PLAN REVIEW SHEET

Petition #: RZP 2022-156

Address: 5201 Nations Ford Rd.

Request: MUDD-CD

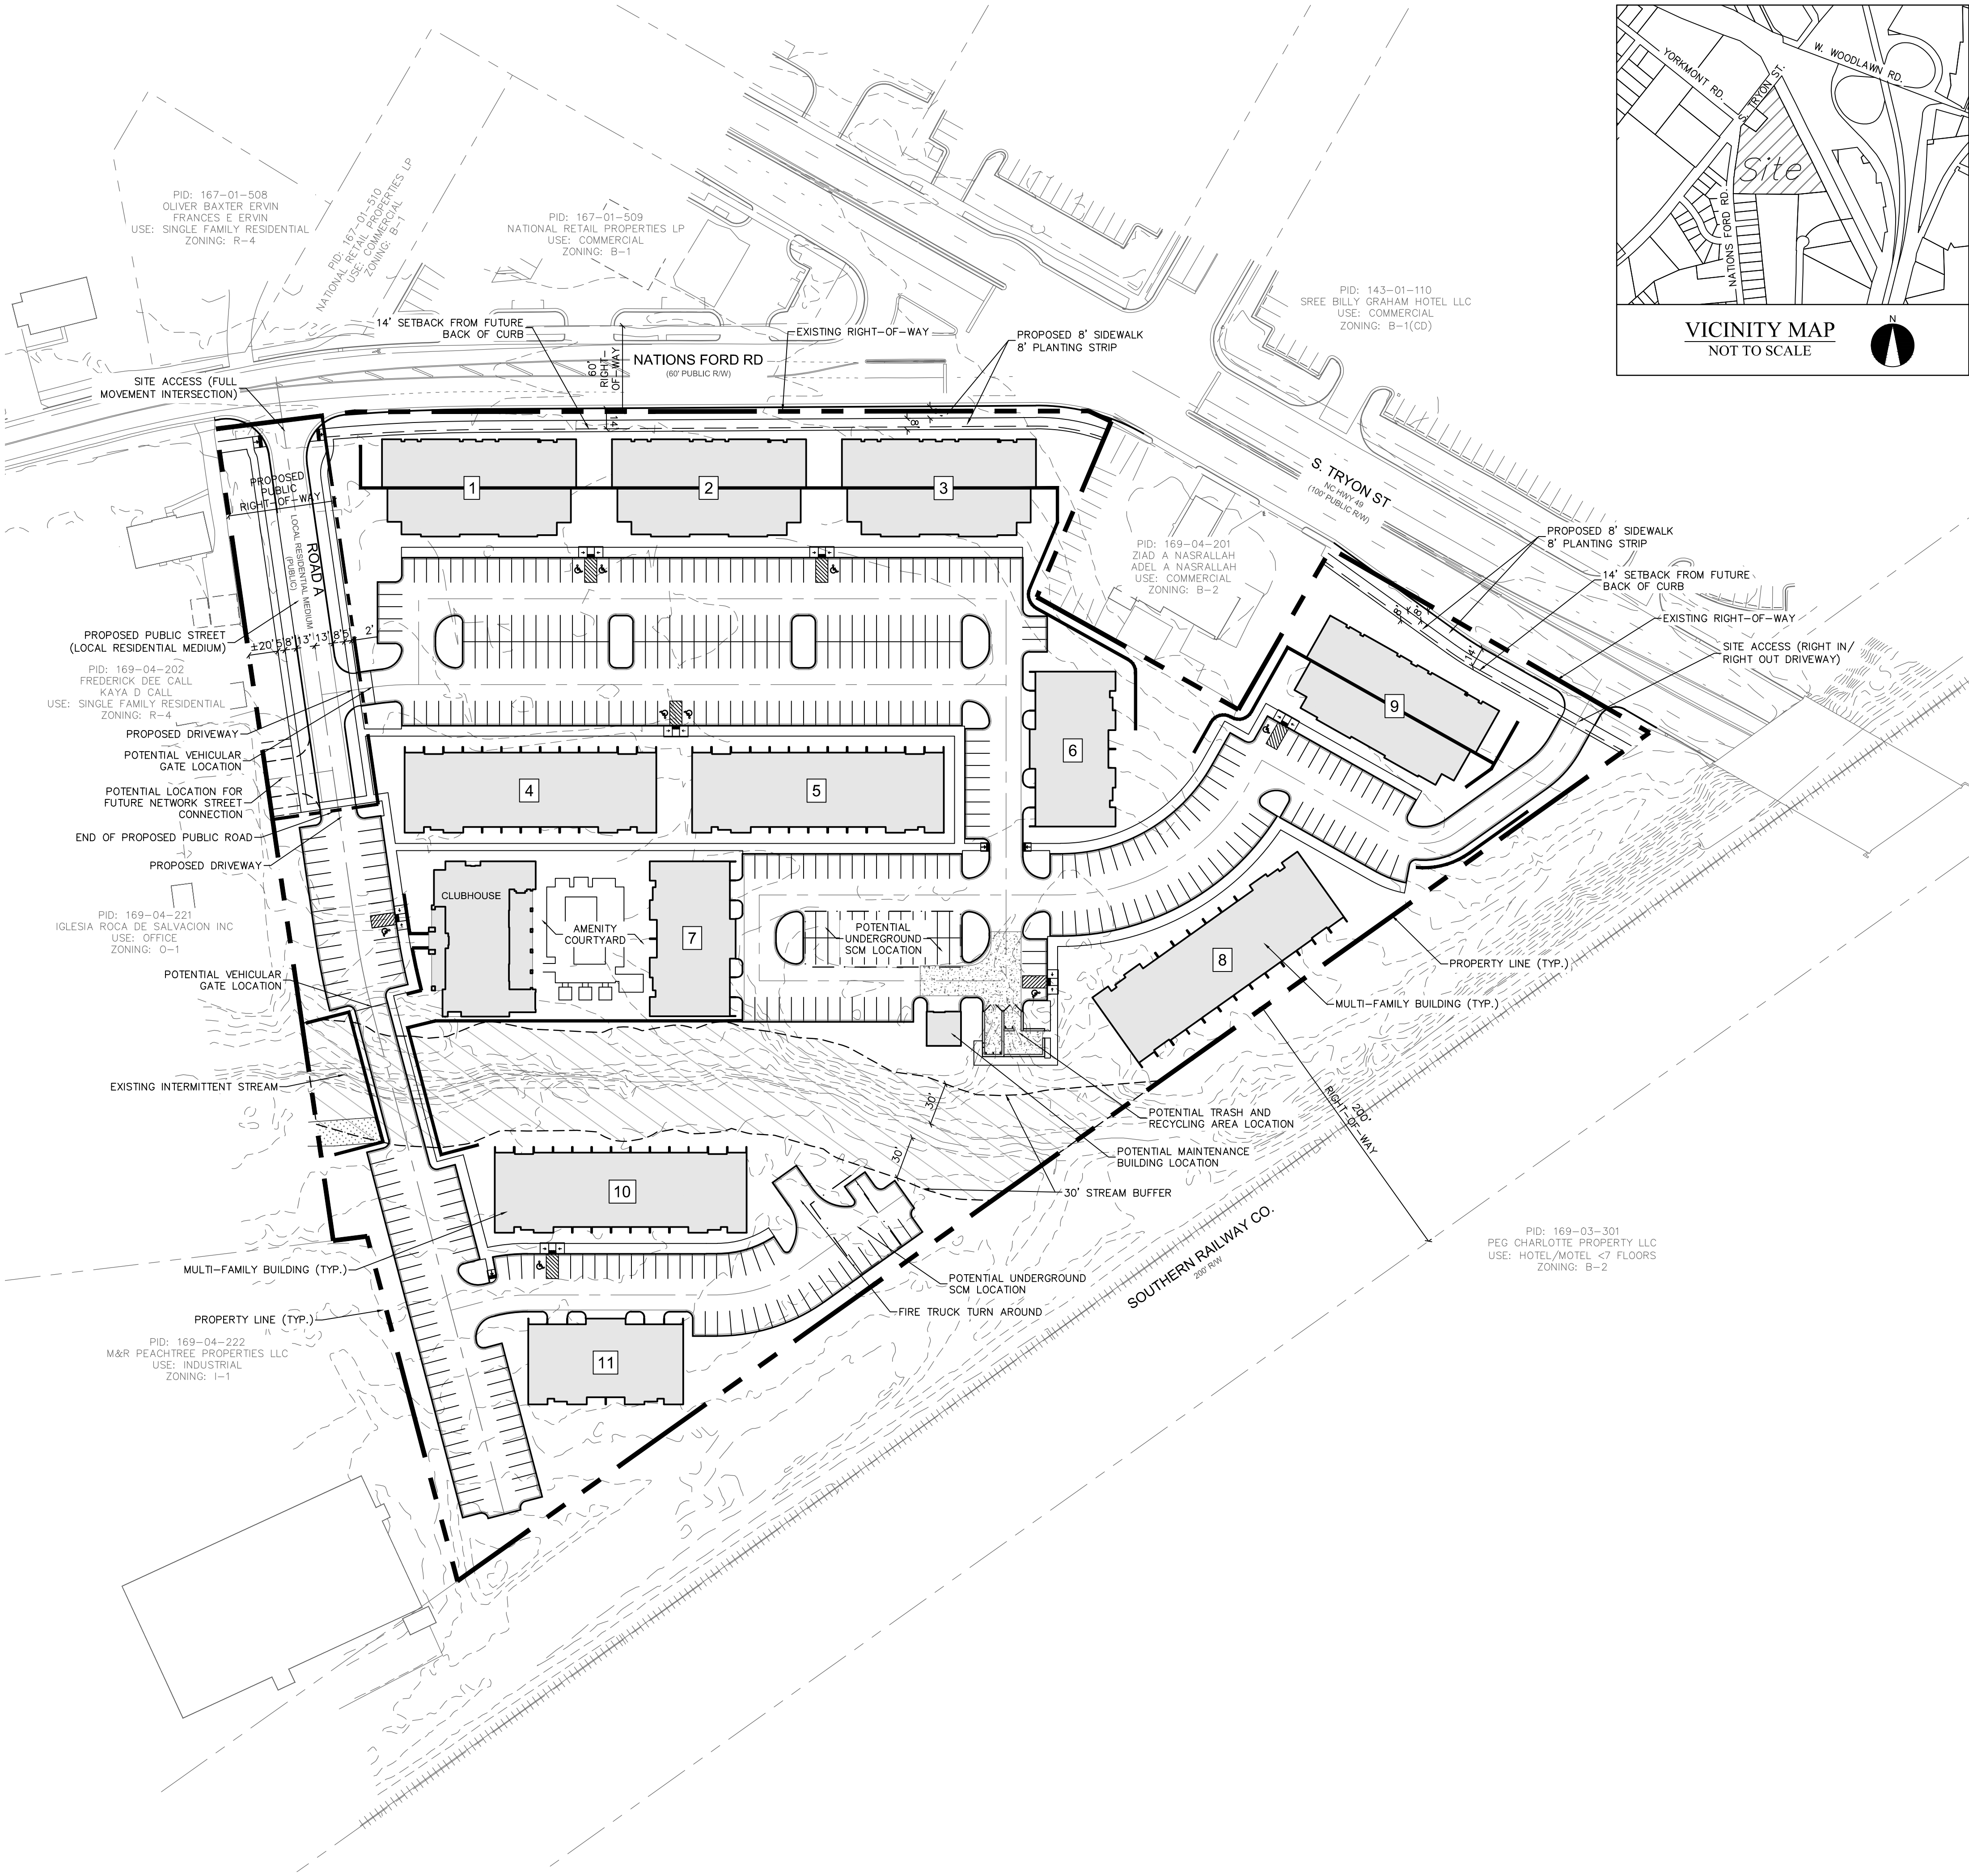
The site is located along CATS express bus route #24 on Nations Ford Rd. CATS requests the construction of ADA compliant bus pad detail 60.03B on Nations Ford Rd. The final location will be coordinated with the developer during the Land Development plan review process.
